ENG-CDR19004-R2-CD-TS-Redlines .pdf Markup Summary

Subject: Callout
Page Index: 1
Date: 7/16/2020 3:15:17 PM
Author: dsdrice
Color: ■
Layer:
Space:
Page Label: [2] 194900_Signal Plan Sheets-Cover

## SIGNAGE AND STRIPING PLAN

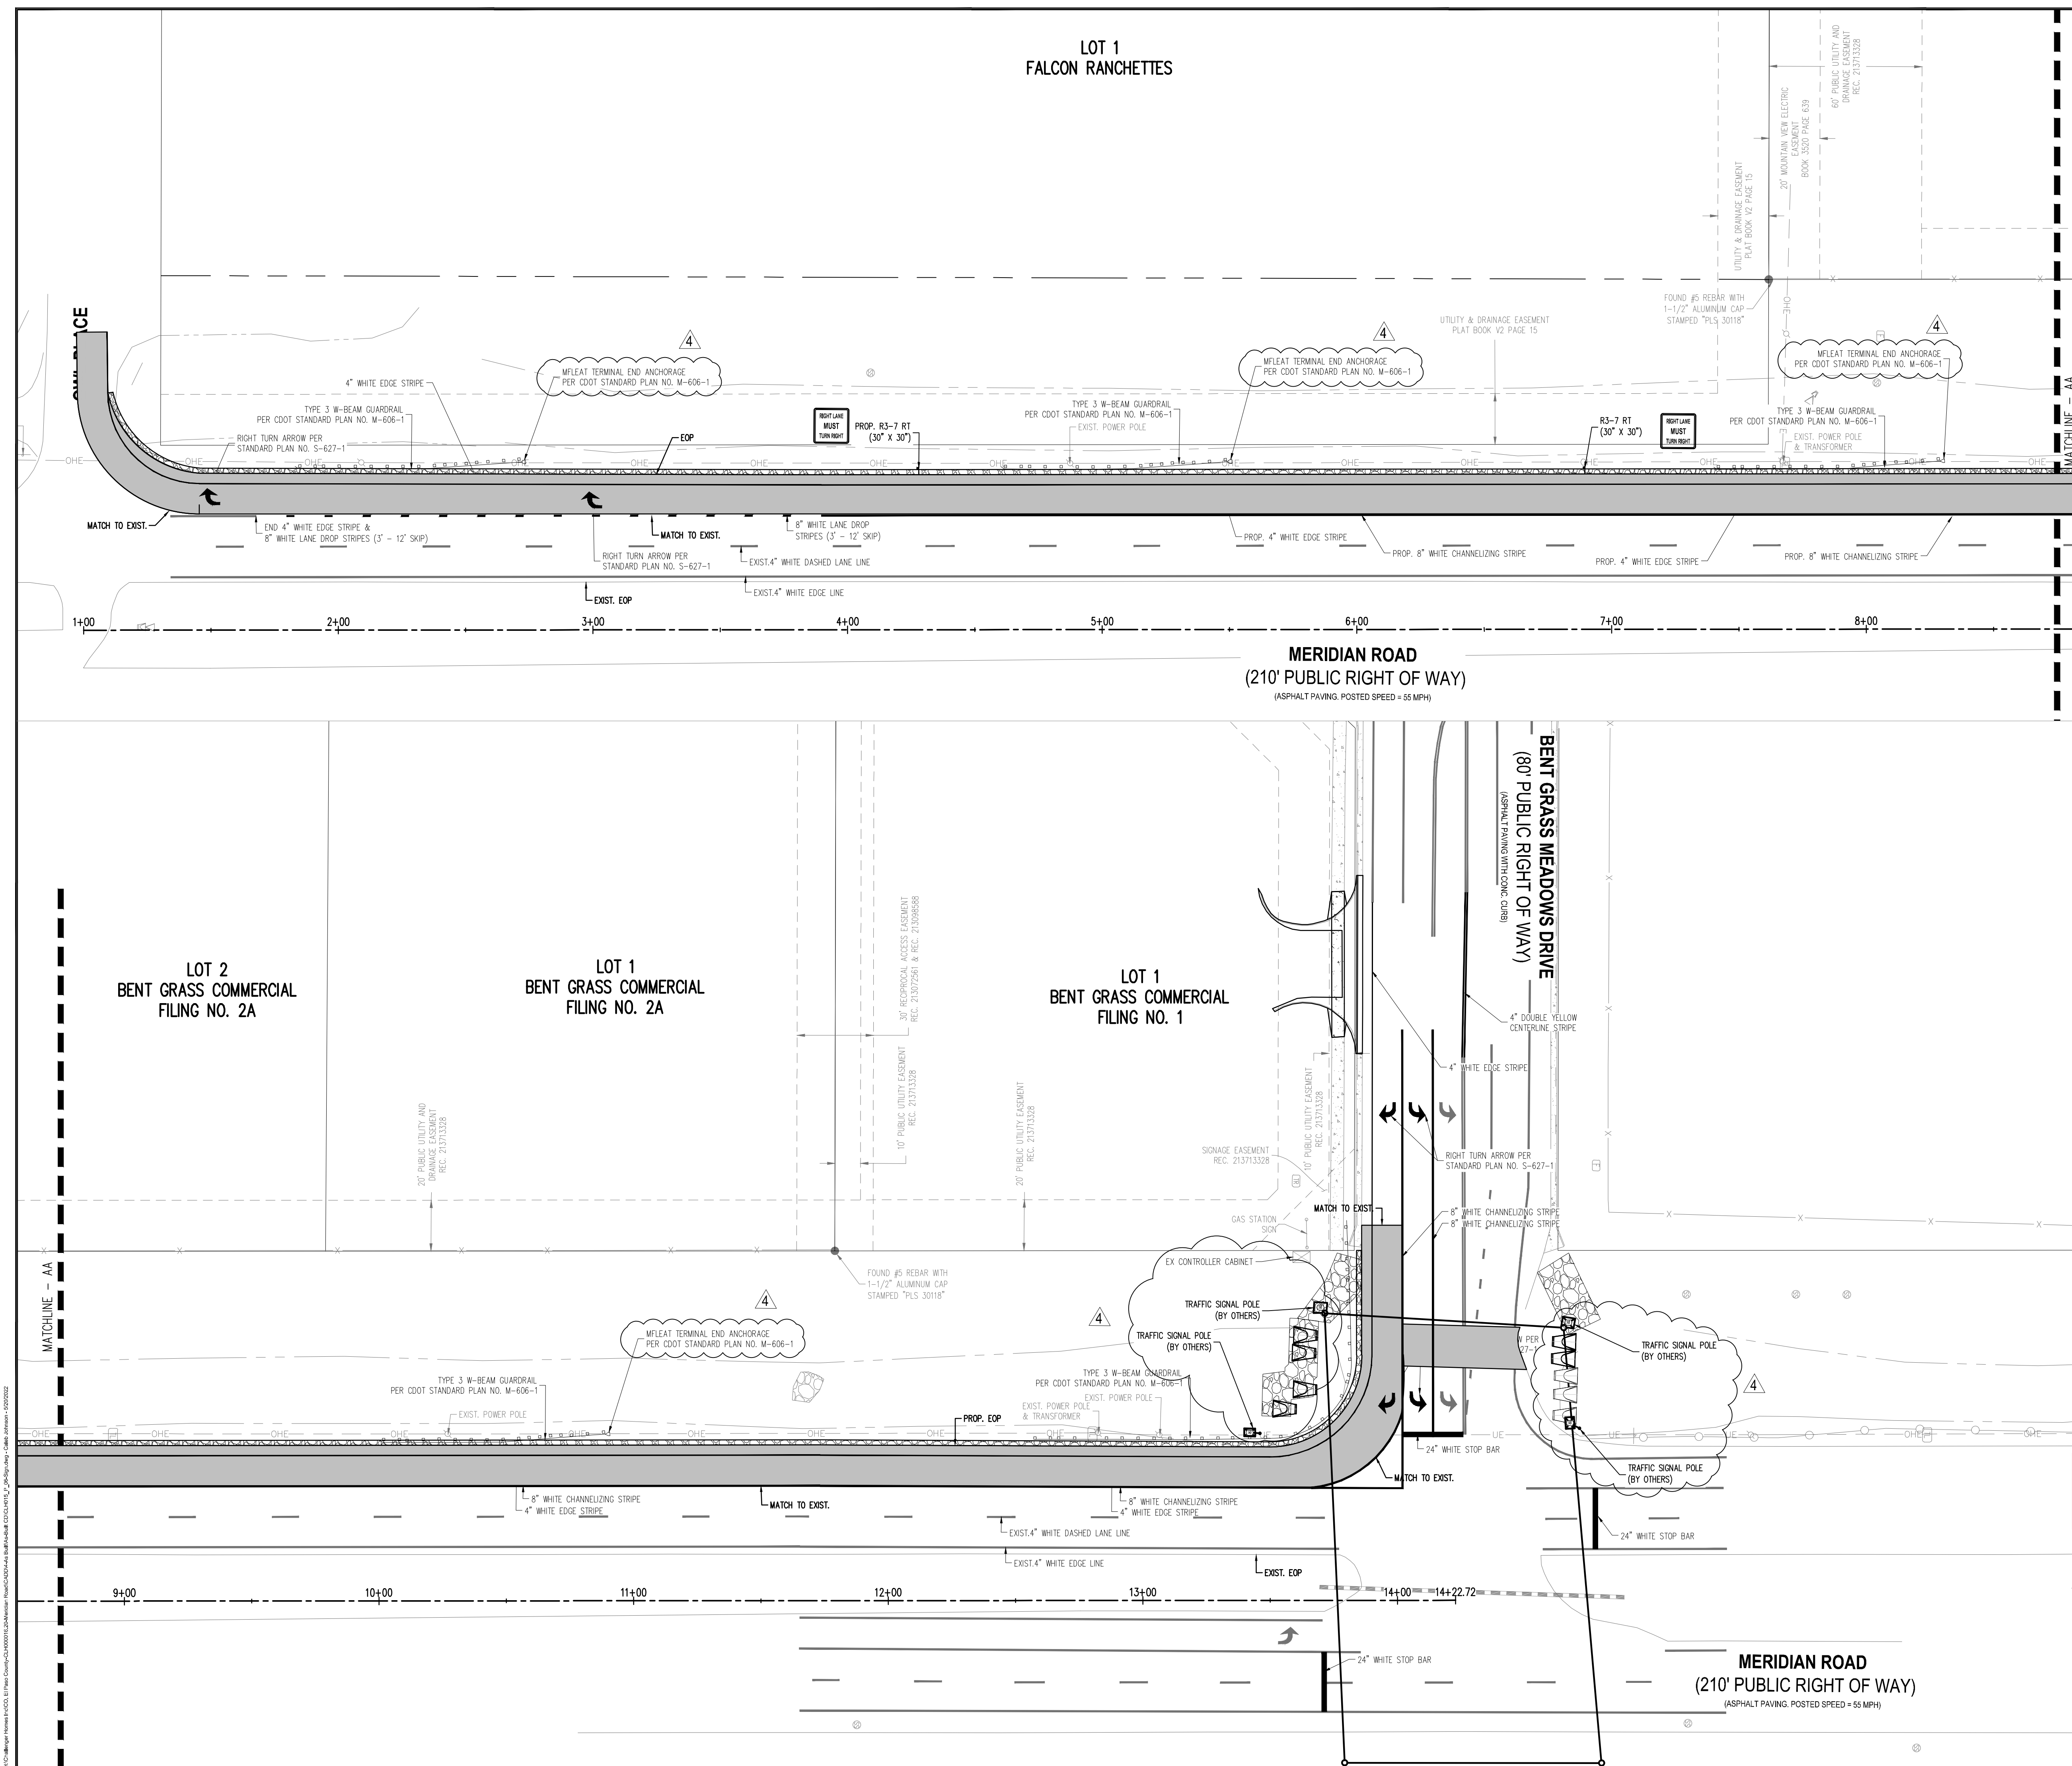
Delete left turn lane stripe and arrow, revise dashed (dotted?) line

close access, show curb and gutter, sidewalk, etc.
